From: Amanda Scholes on behalf of Planning.Responses
Sent: 27 June 2019 08:54
To: Planning Scanning
Subject: FW: LU/133/19/PL - Site of Inglecroft Barn Close Littlehampton West Sussex BN17 6JU

I see that the applicant has submitted further drainage details for this application. The information submitted includes winter groundwater monitoring, a result from an infiltration test, calculations, a proposed layout, and a construction detail drawing. I have the following comments on the details submitted:

DRIVE DETAIL
SCALE 1:10

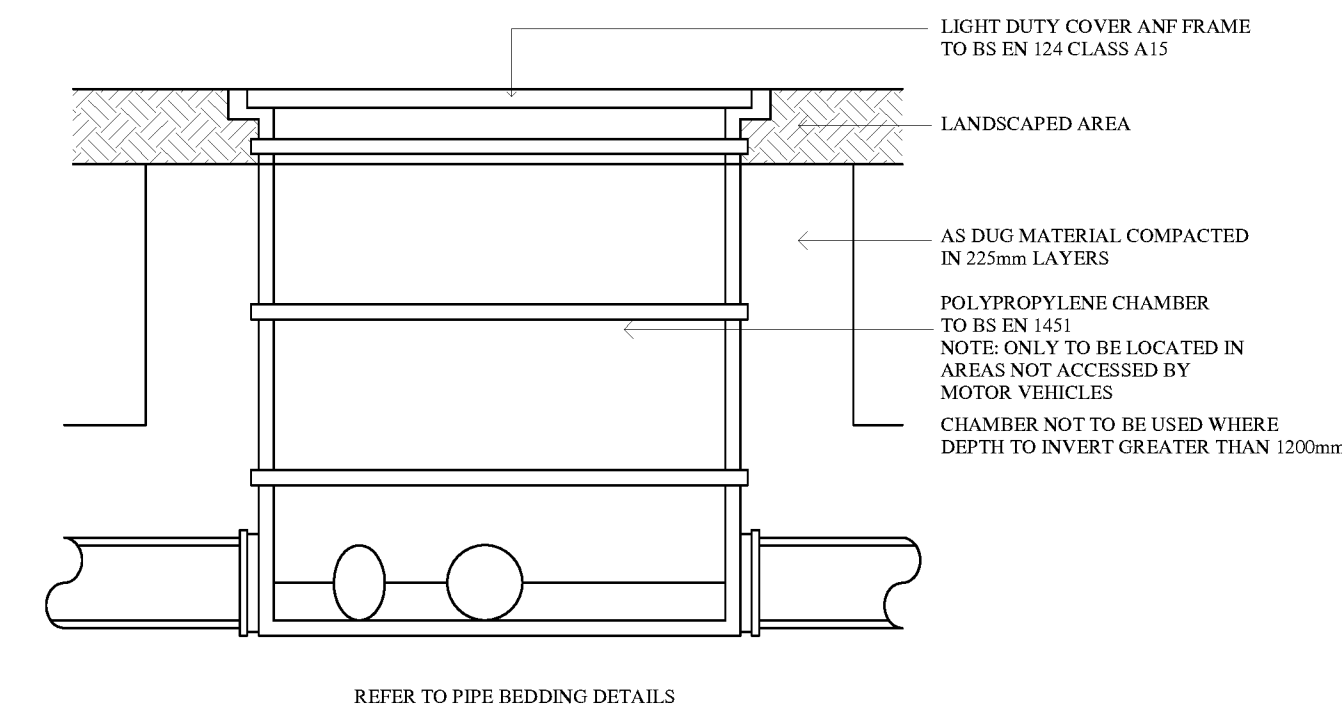
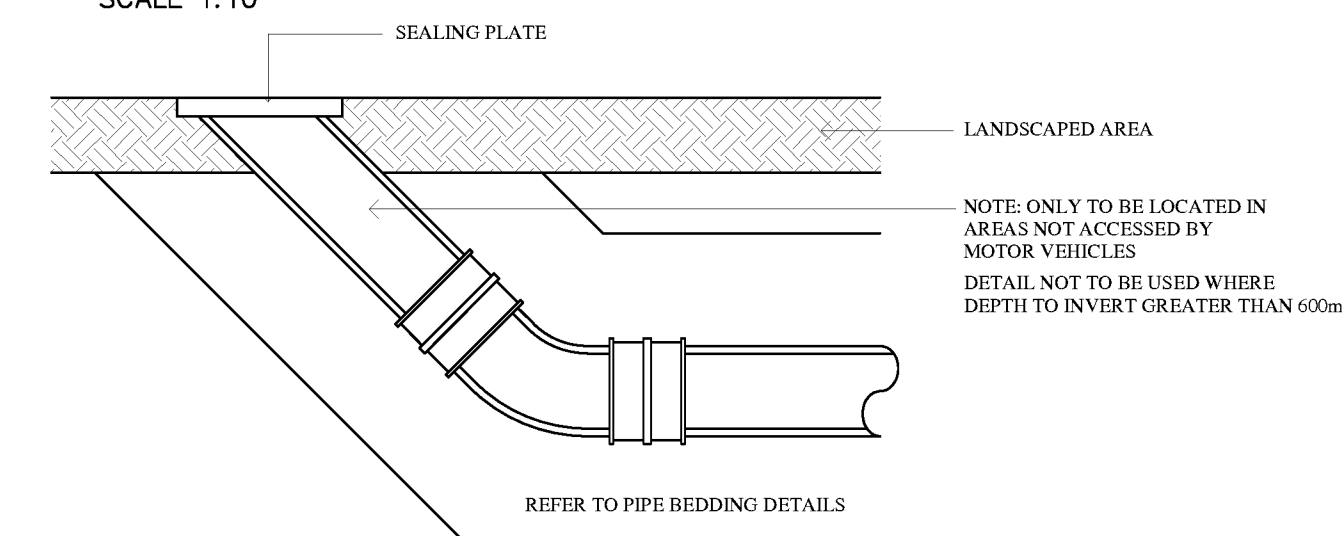
6. No maintenance details have been provided.
7. The construction detail drawing of the soakaways does not clearly identify cover depth requirements over crates.

8. Construction detail drawings need to be submitted of manholes, pipe bedding details, and silt traps.
